Submission of Planning Authority on an application for approval under Section 182A of Planning and Development Act 2000 (as amended).

Re: Proposed development of a 110kV substation and associated works in the townlands of Ballynamullagh, Kilmurry, Coolree, Killyon and Drehid, Co. Kildare.

Planning Report

Planning Number: 25/322843
Applicant: North Kildare Wind Farm Ltd
Address: Drehid Substation, Carbury and Timahoe, Co. Kildare
Date: 30/7/25 Revised for commentary and layout

Drawing file: Drawings / 23727-MWP-00-00-DR-C-1200_BRIDGE 1 DETAILS.pdf

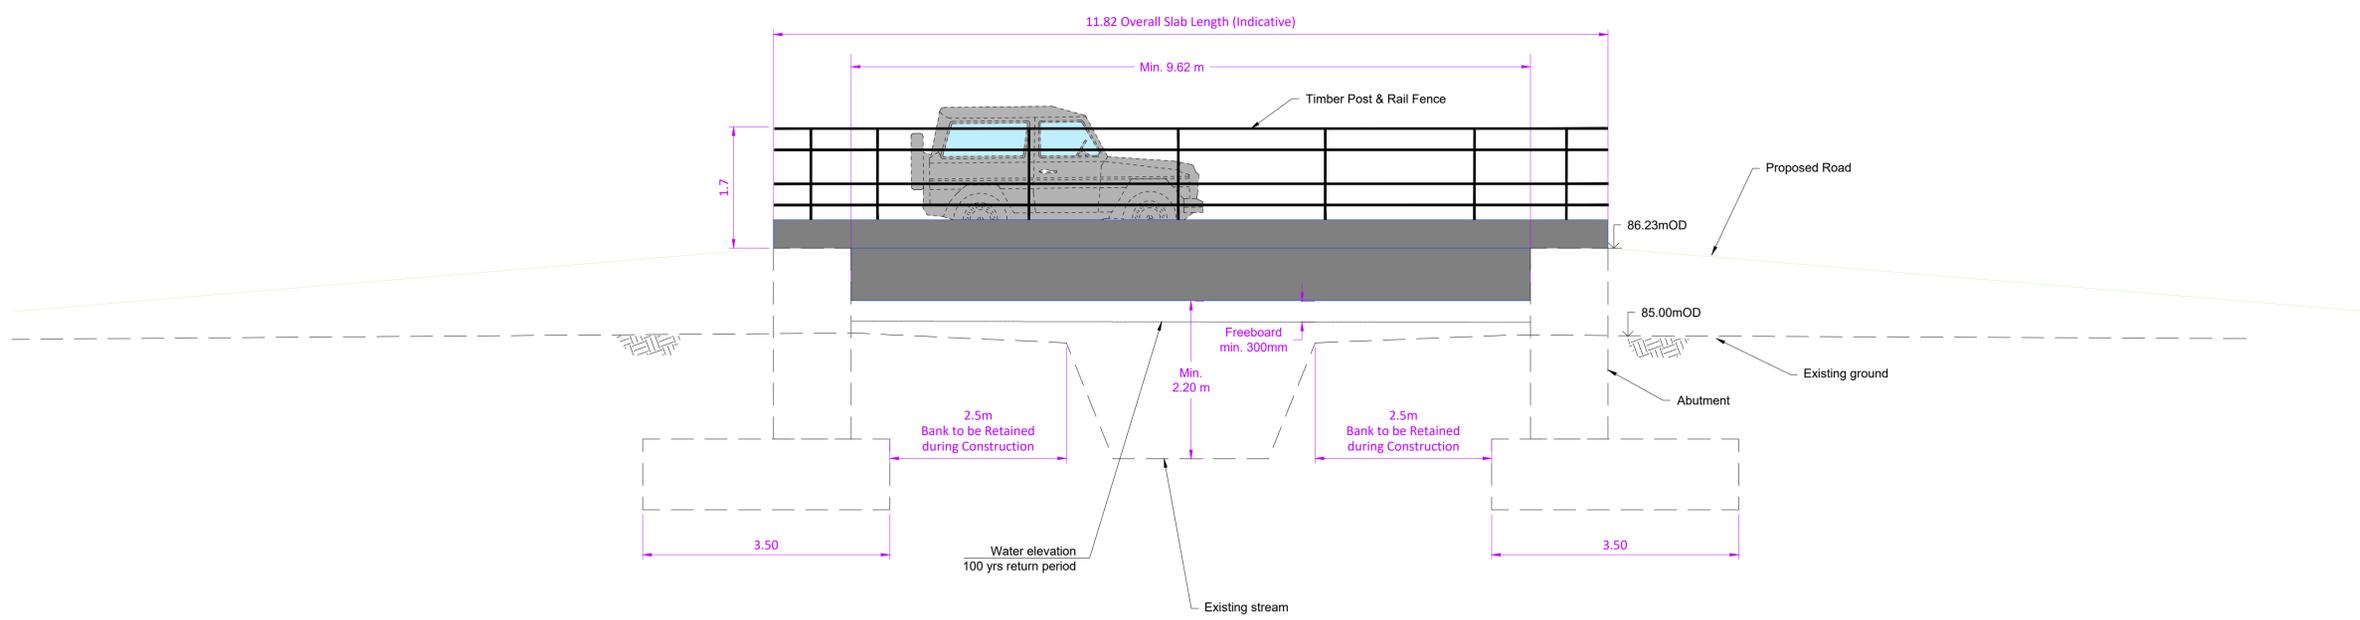
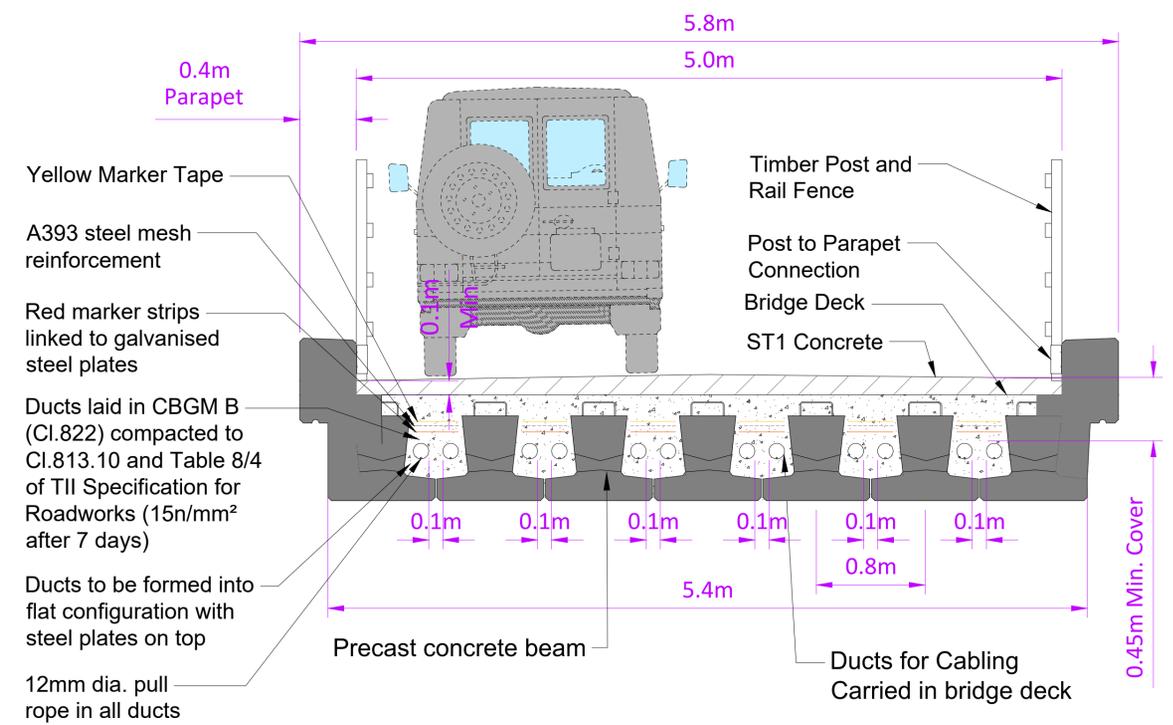
9. Prior to commencement a structural assessment of any bridges on the haul routes to determine their structural stability, shall be completed and any improvement measures necessary, be undertaken.

PROJECT		CLIENT	
DREHID WIND FARM & SUBSTATION		NORTH KILDARE WIND FARM Ltd.	
SHEET	SITE ACCESS MAIN ENTRANCE		Rev. A
	Date 11.03.25	Project number P22-242	Scale (@ A1-) 1:500
	Drawn by CS	Drawing Number	
	Checked by BC	P22-242-0300-0015

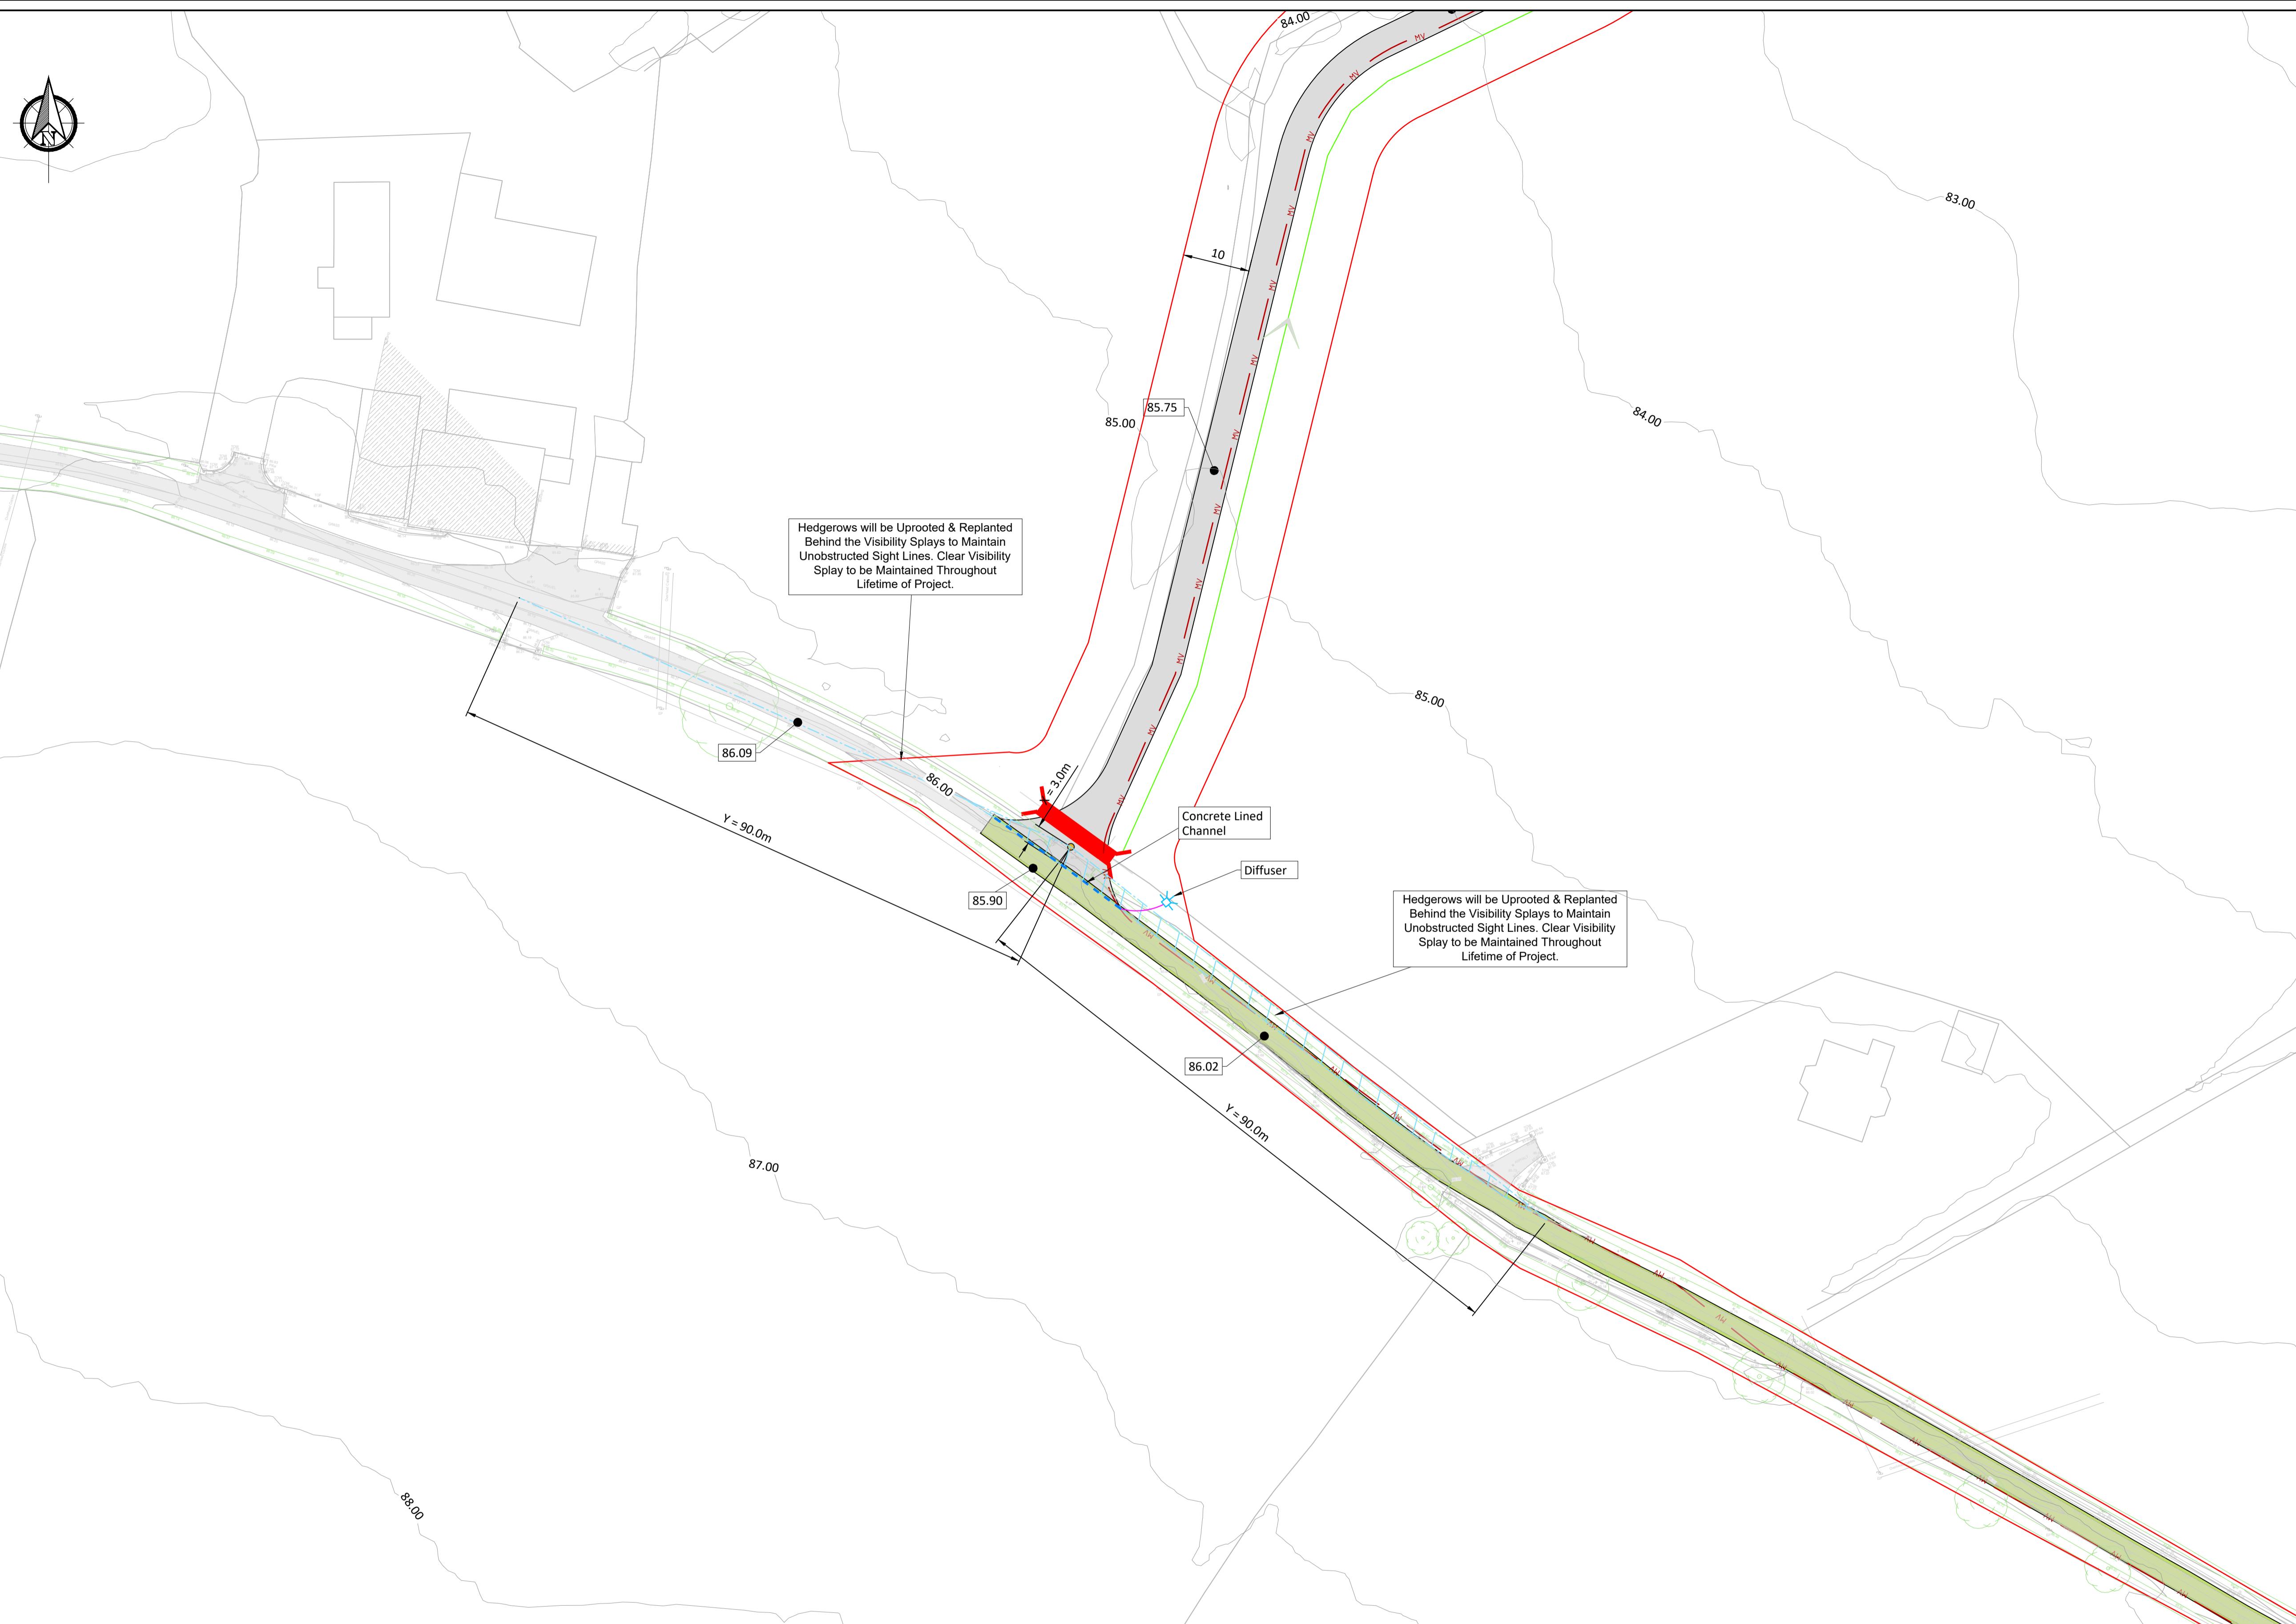
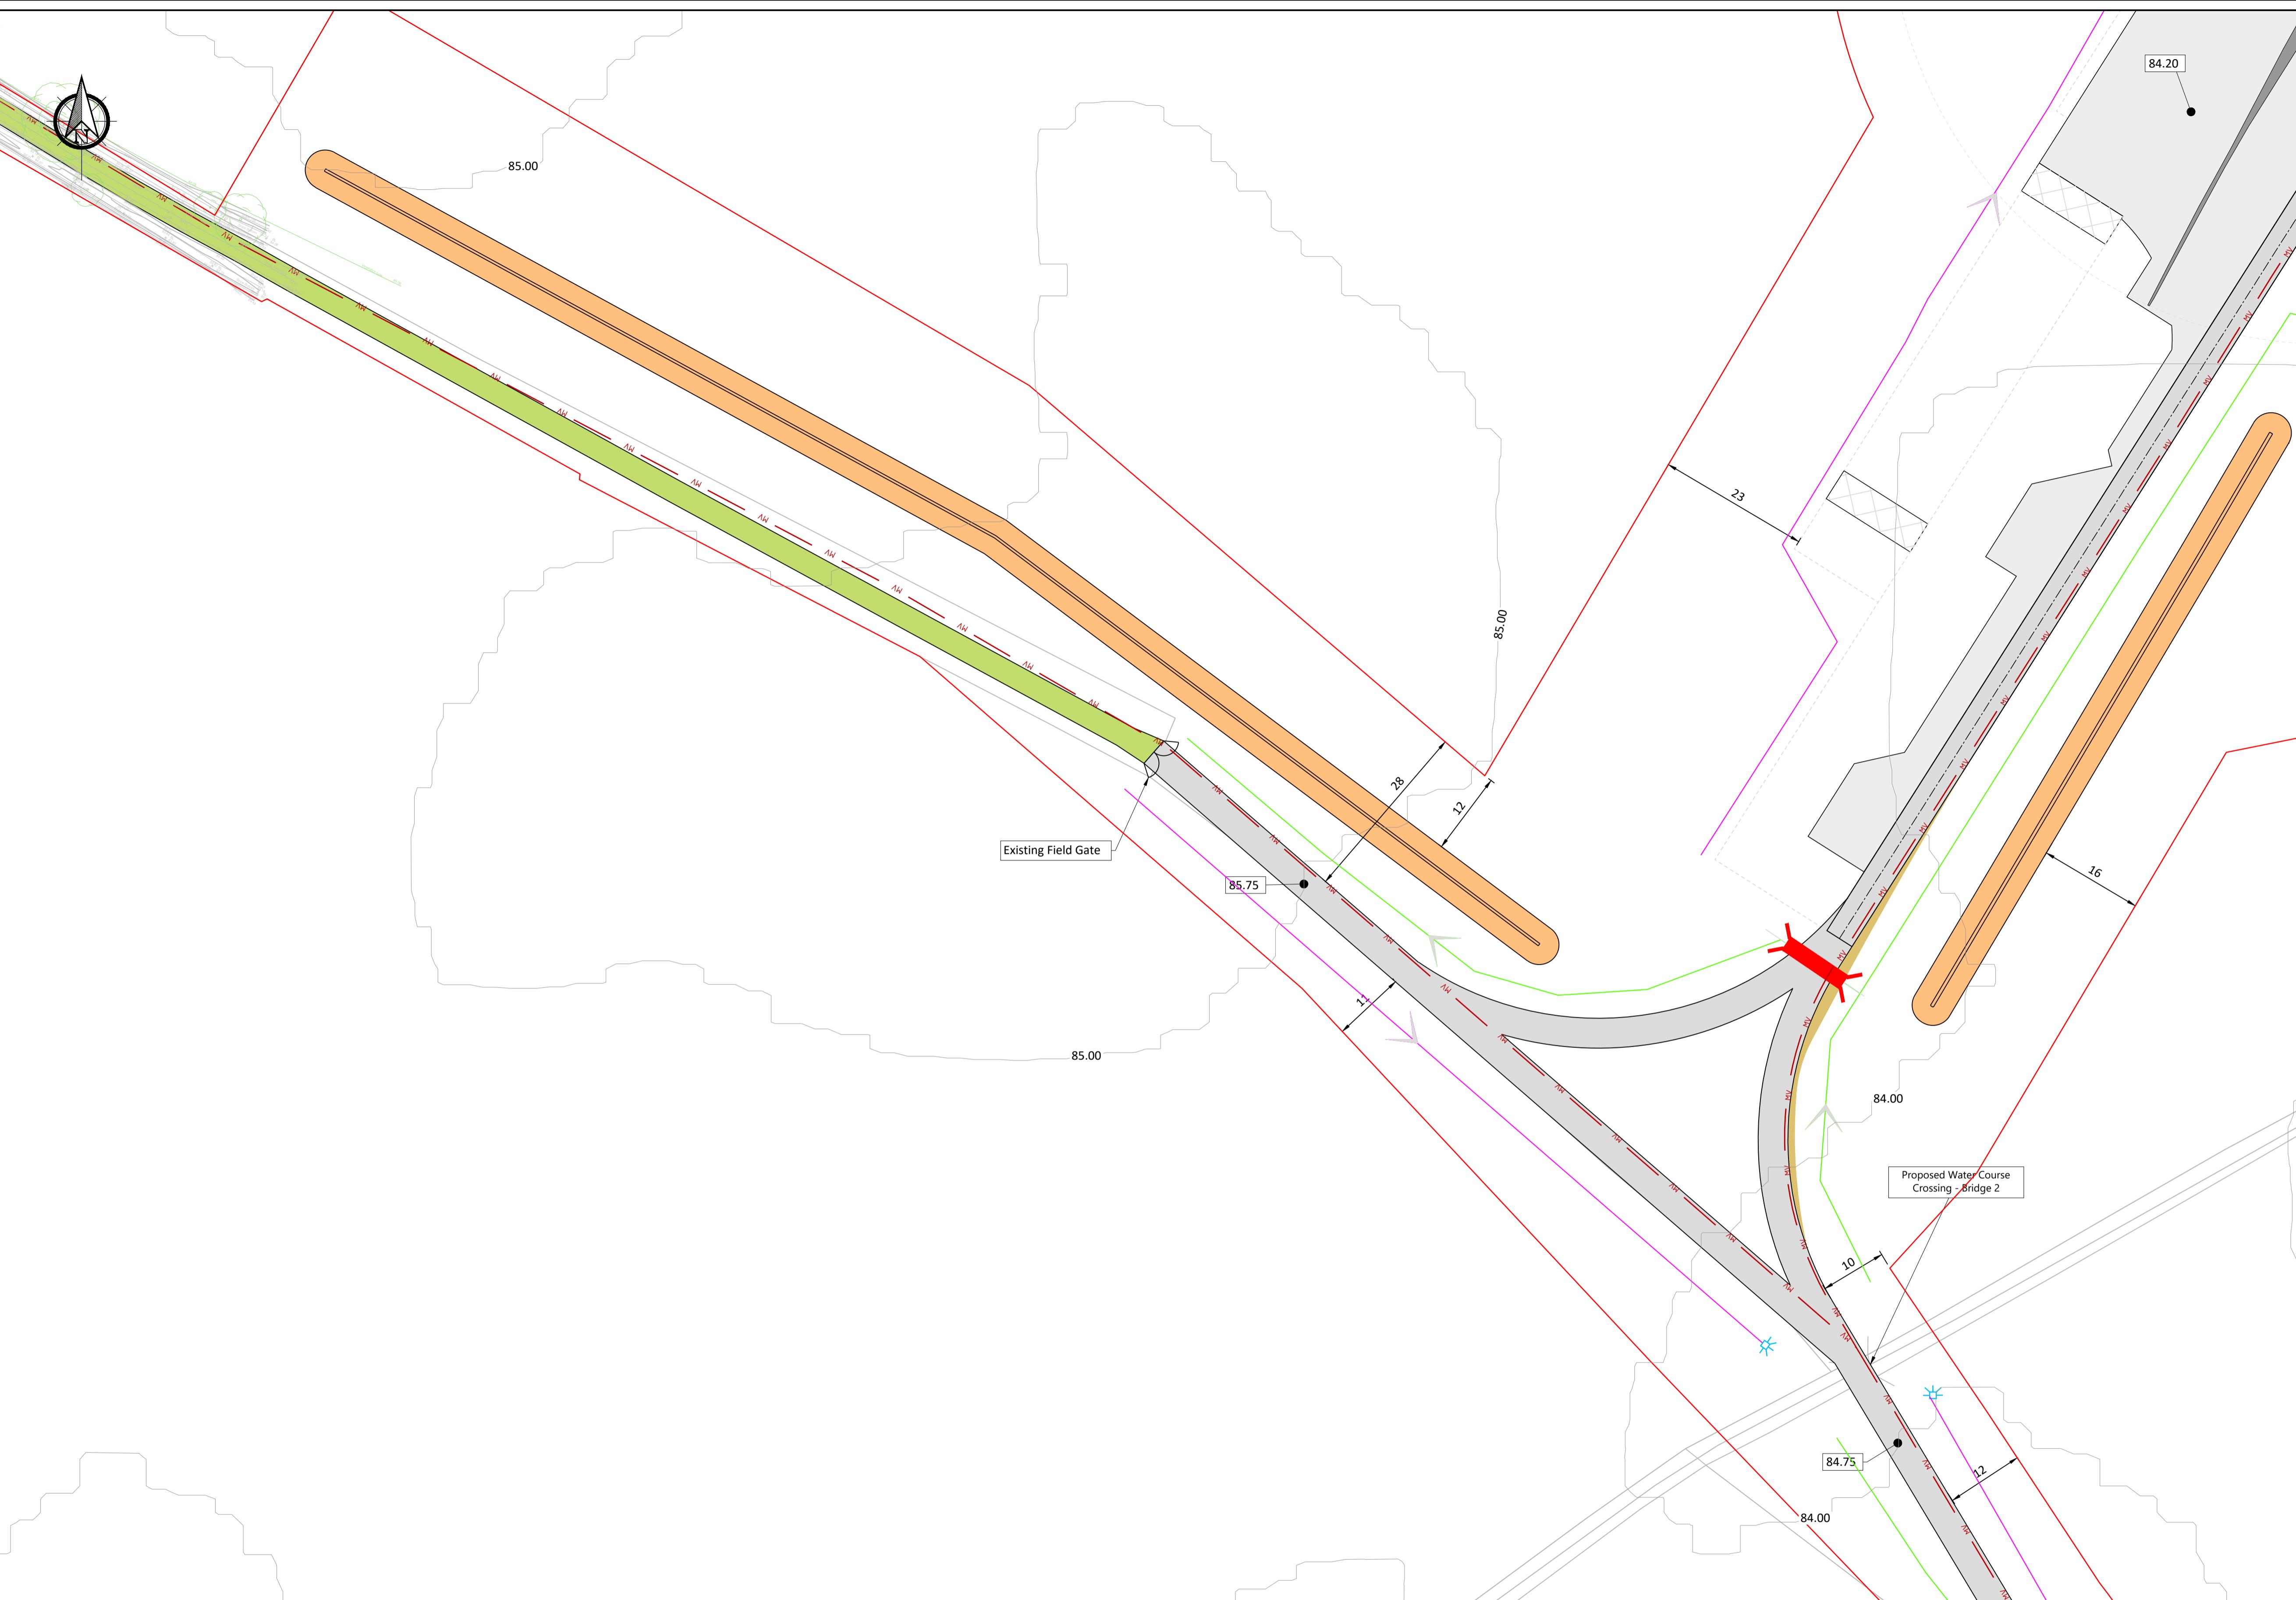
7. Prior to commencement the Applicant shall submit Three separate drawings for all entrances on L5012, L50242 and L5025 including a swept path analysis and sightlines for all entrances into the proposed development.
